**Great North Road Solar and Biodiversity Park EN010162
Post Hearing Submission from Nottinghamshire County Council
18th February 2026 (Examination Deadline 3)**

Nottinghamshire County Council (NCC) submits the following post hearing statement at Deadline 3. This statement is a written summary of the oral representations made by NCC at the hearings held during week commencing 2nd February 2026, supplemented with further clarification where necessary.

0 0.25 0.5 1 km

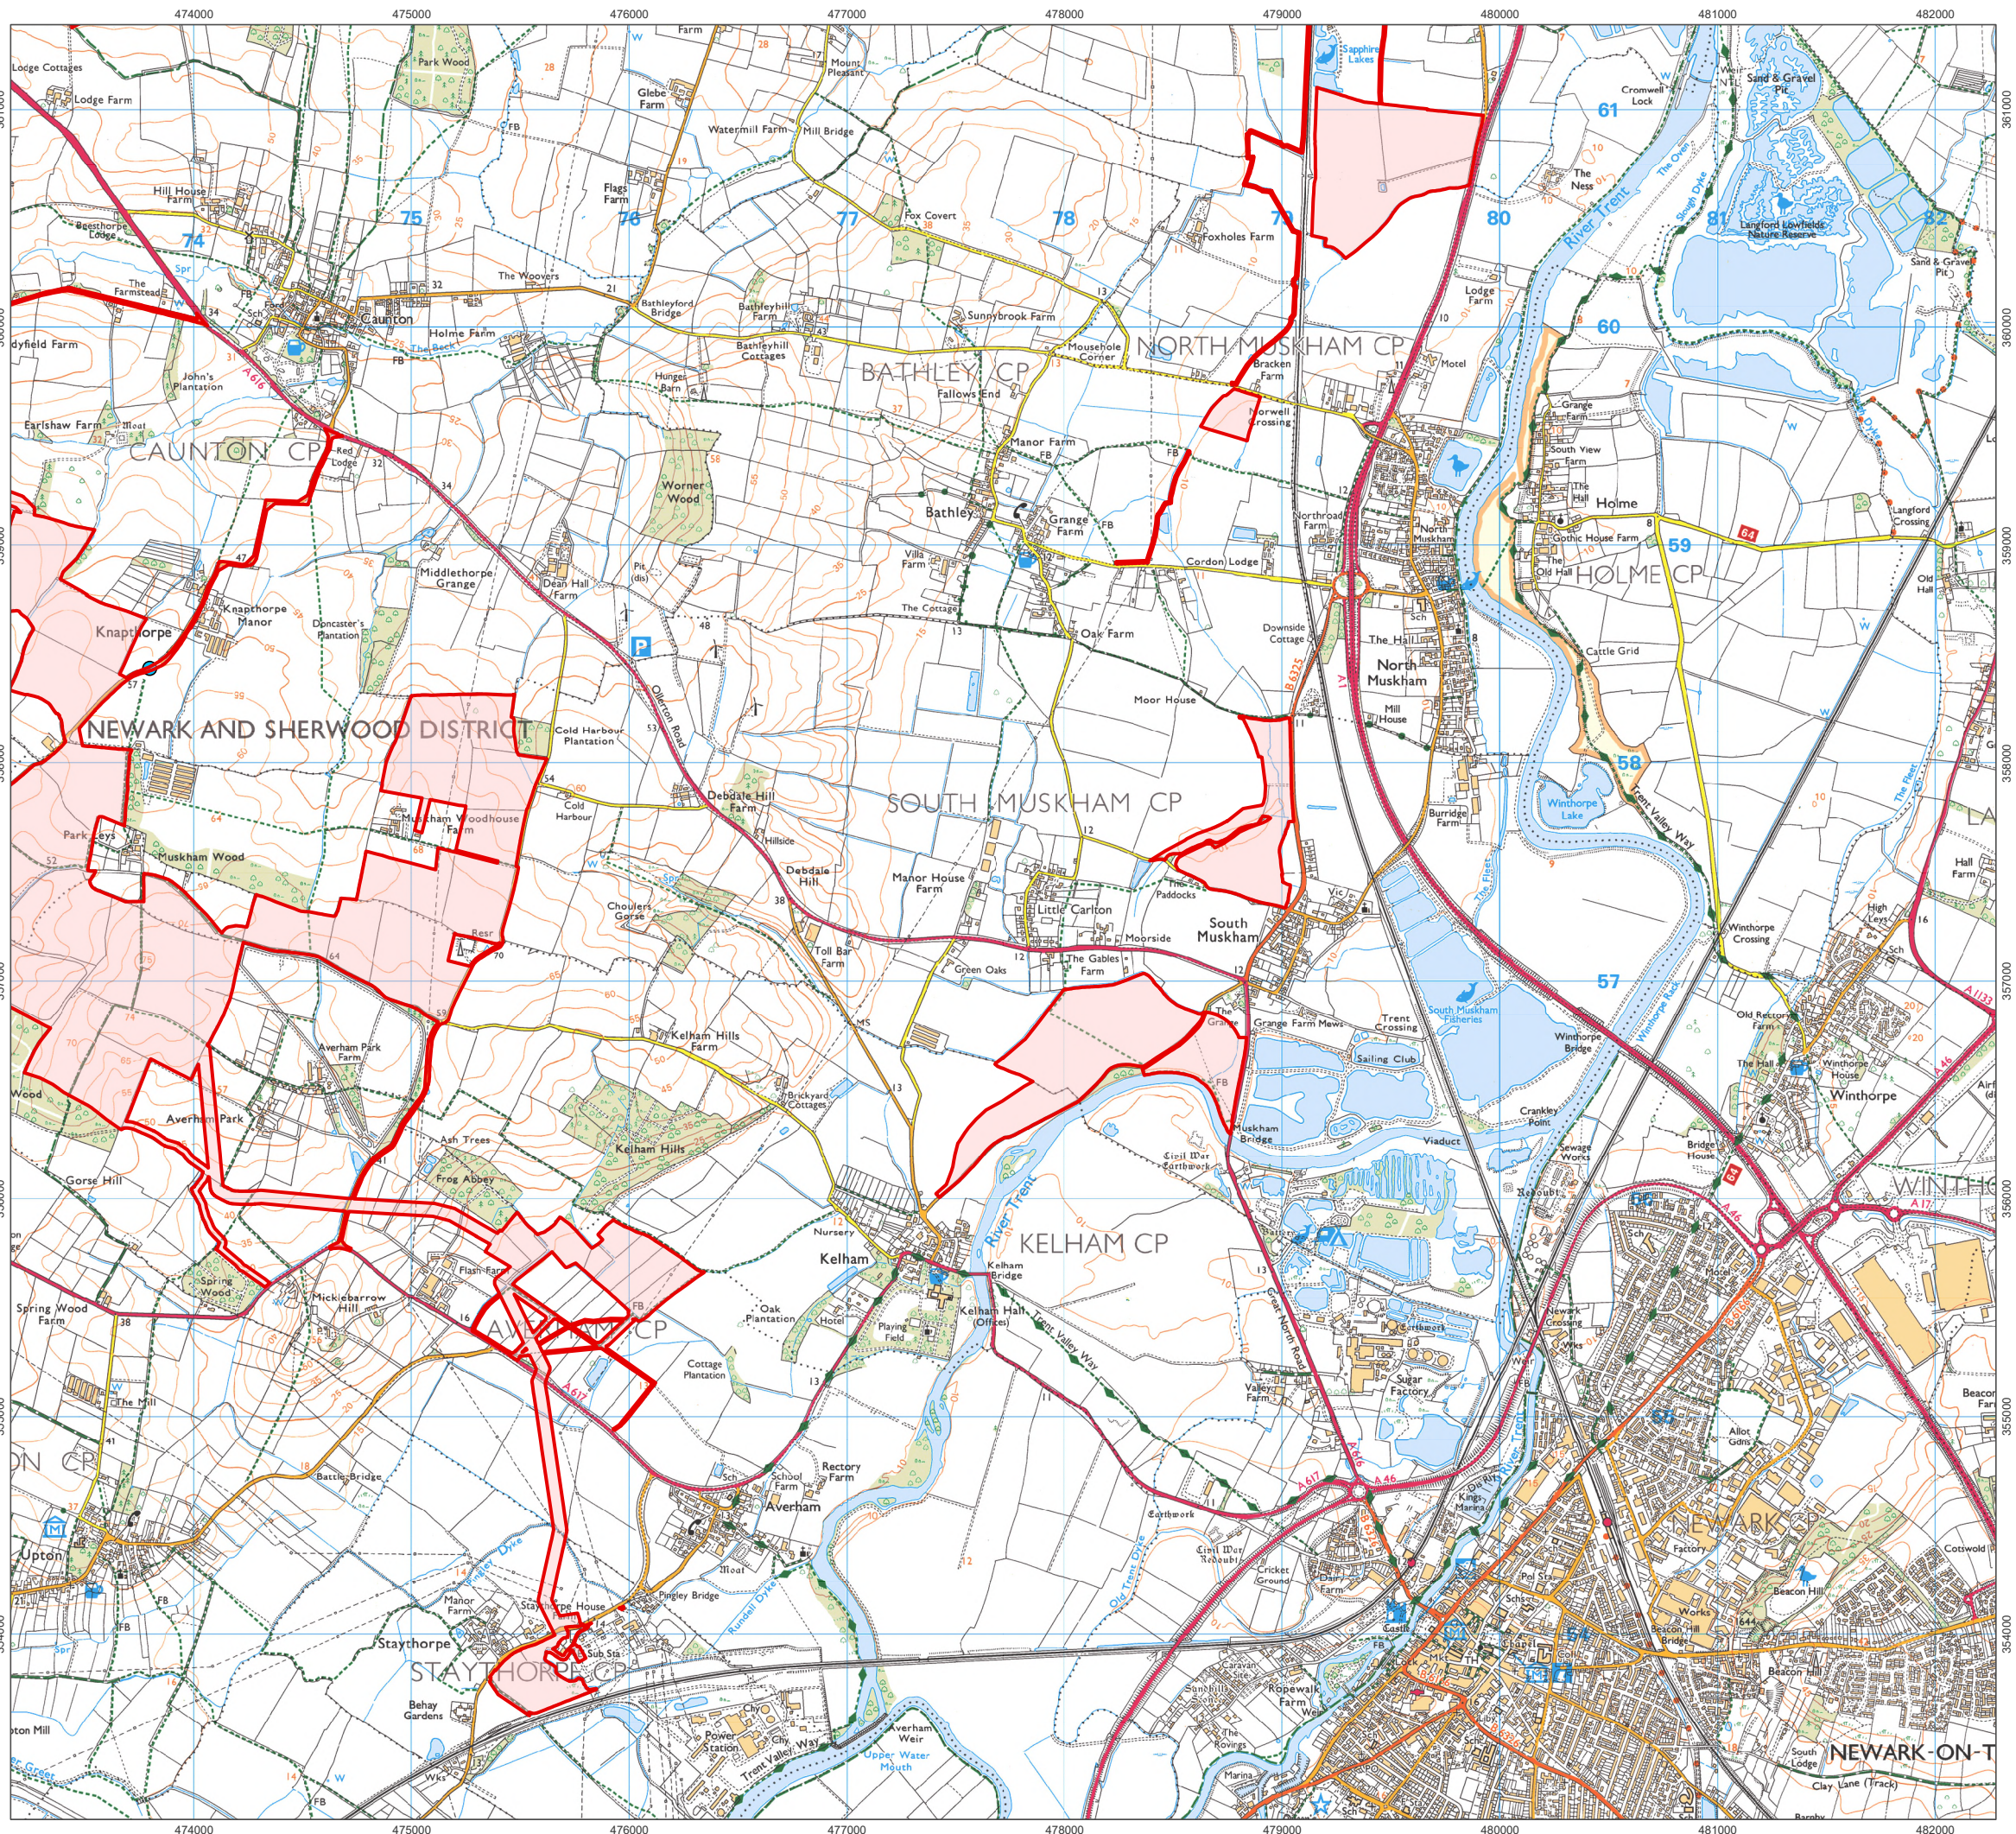
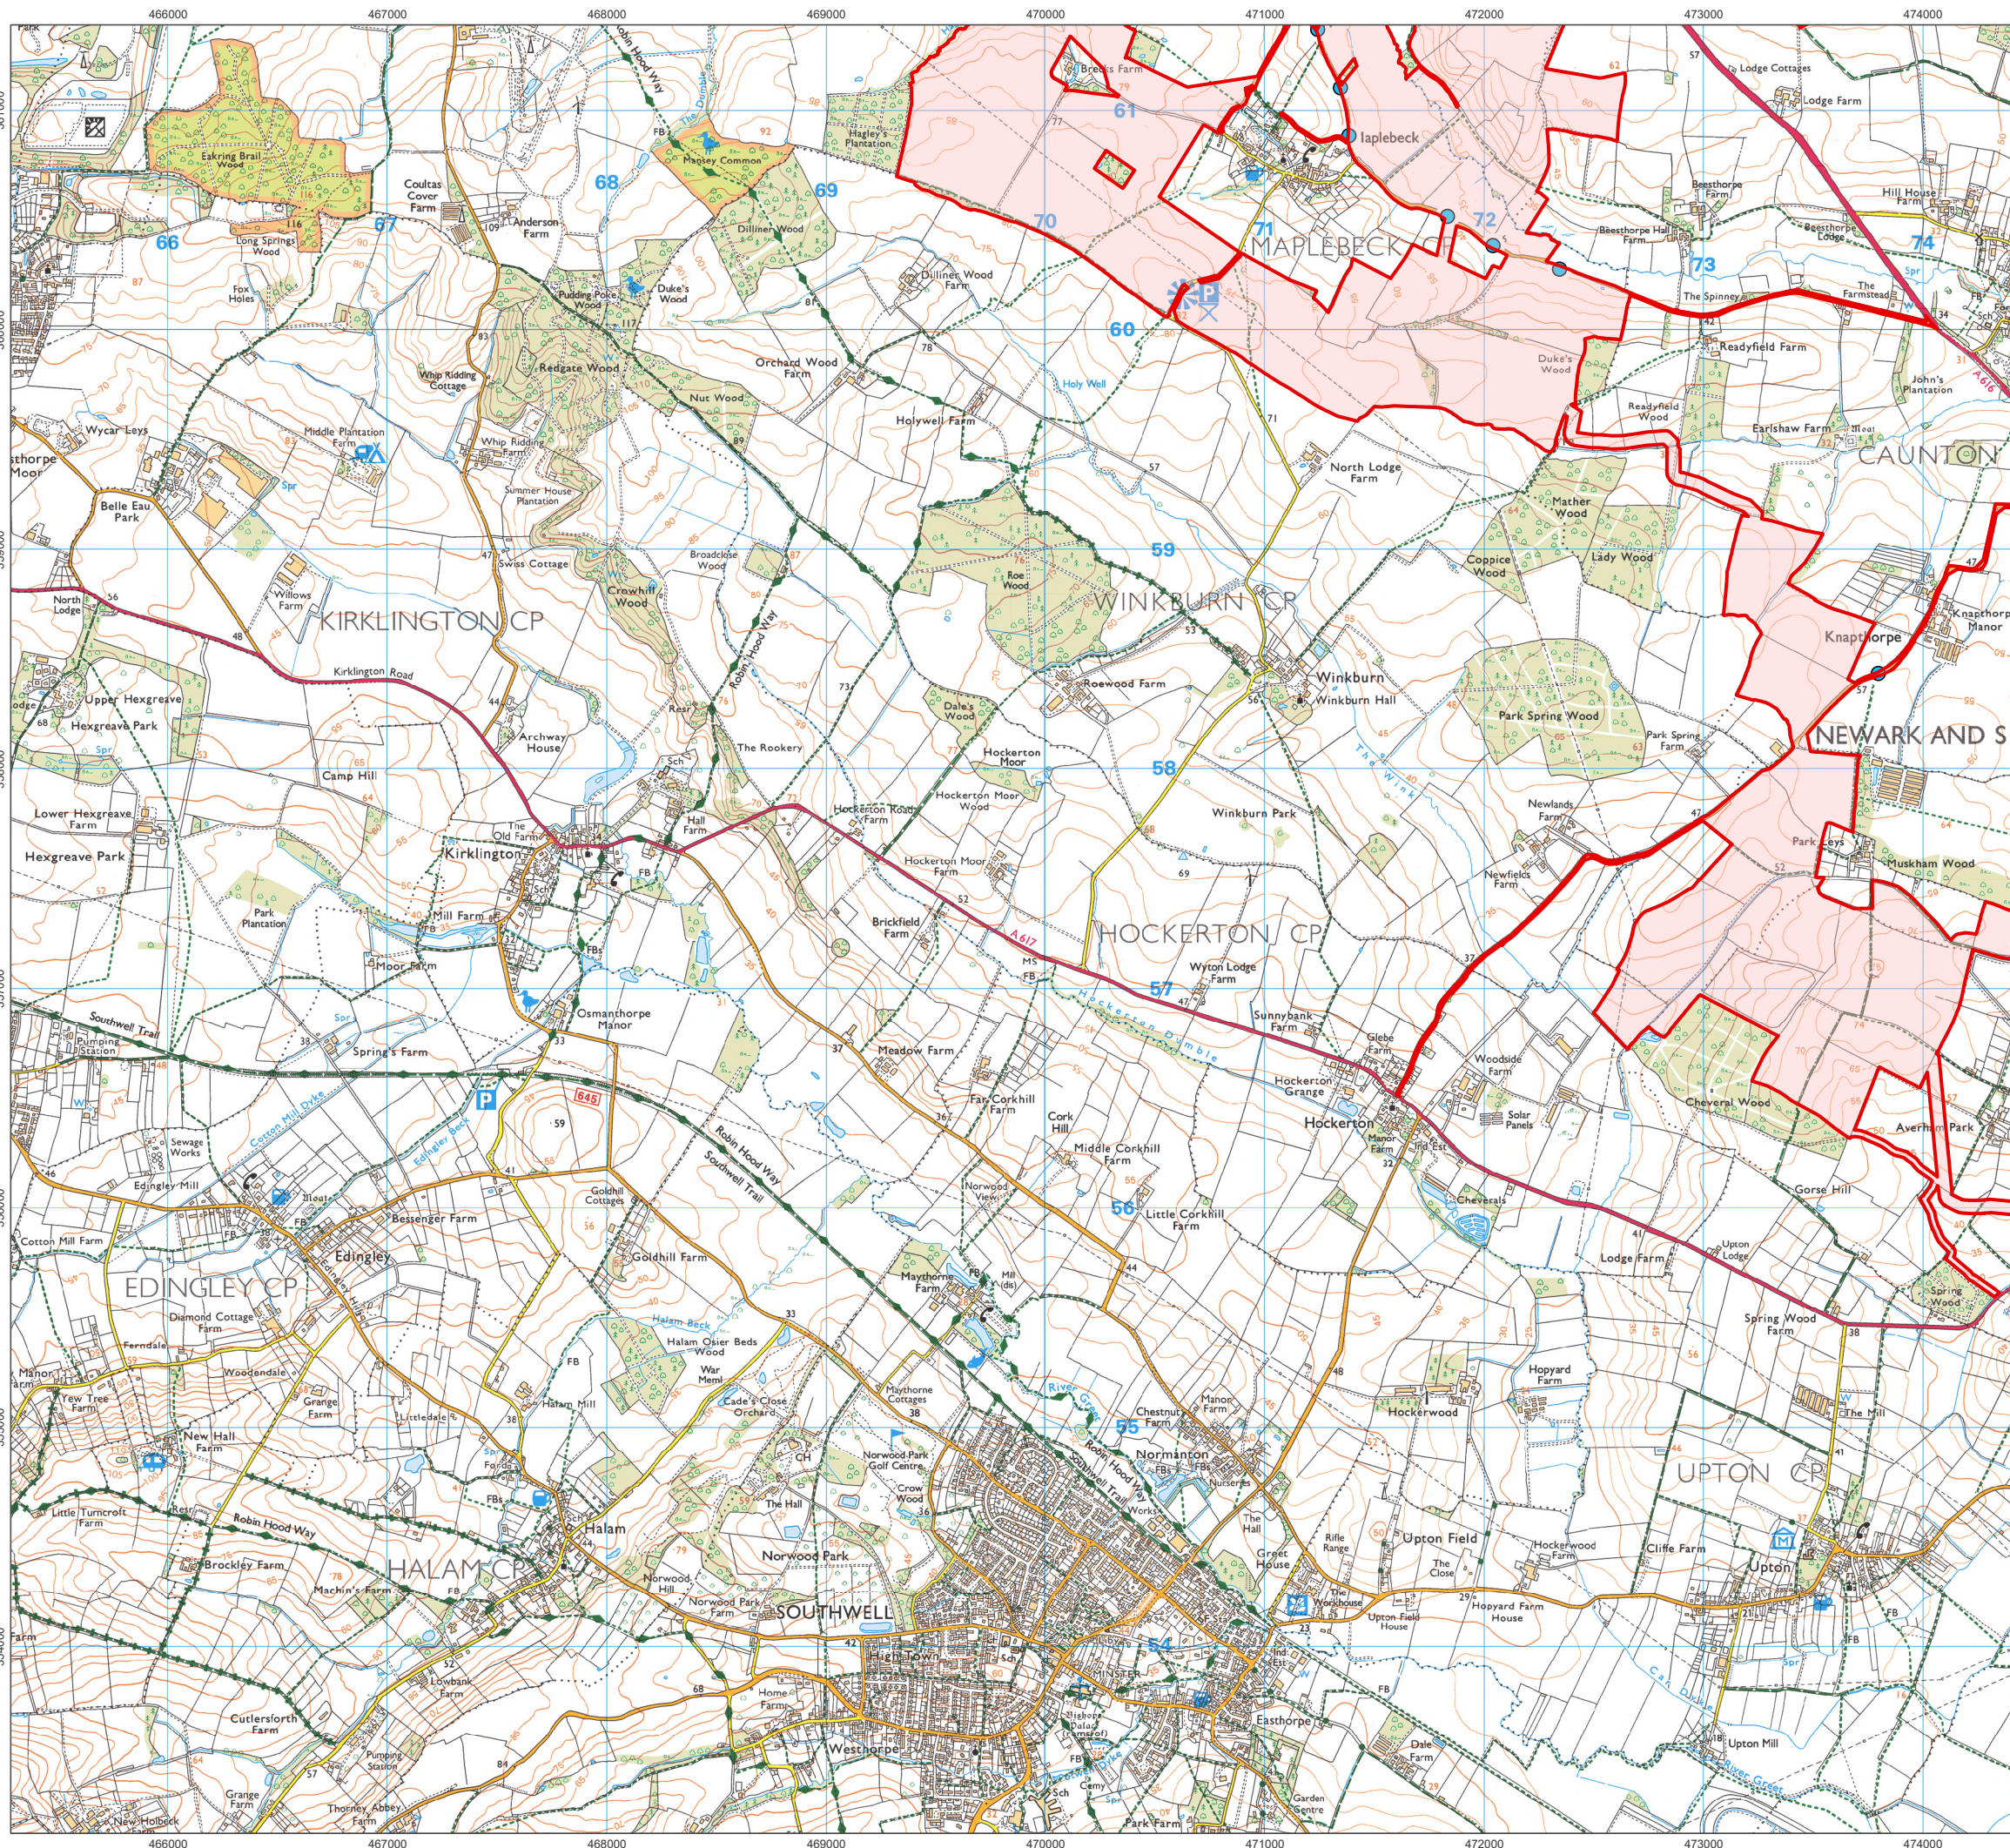
16. NCC recommended that all passing places to be installed on the highway are permanent, rather than temporary as proposed. This is because they are a necessary feature of the operational phase (to facilitate HGV access for replacement of the solar panels) as well as the decommissioning phase.
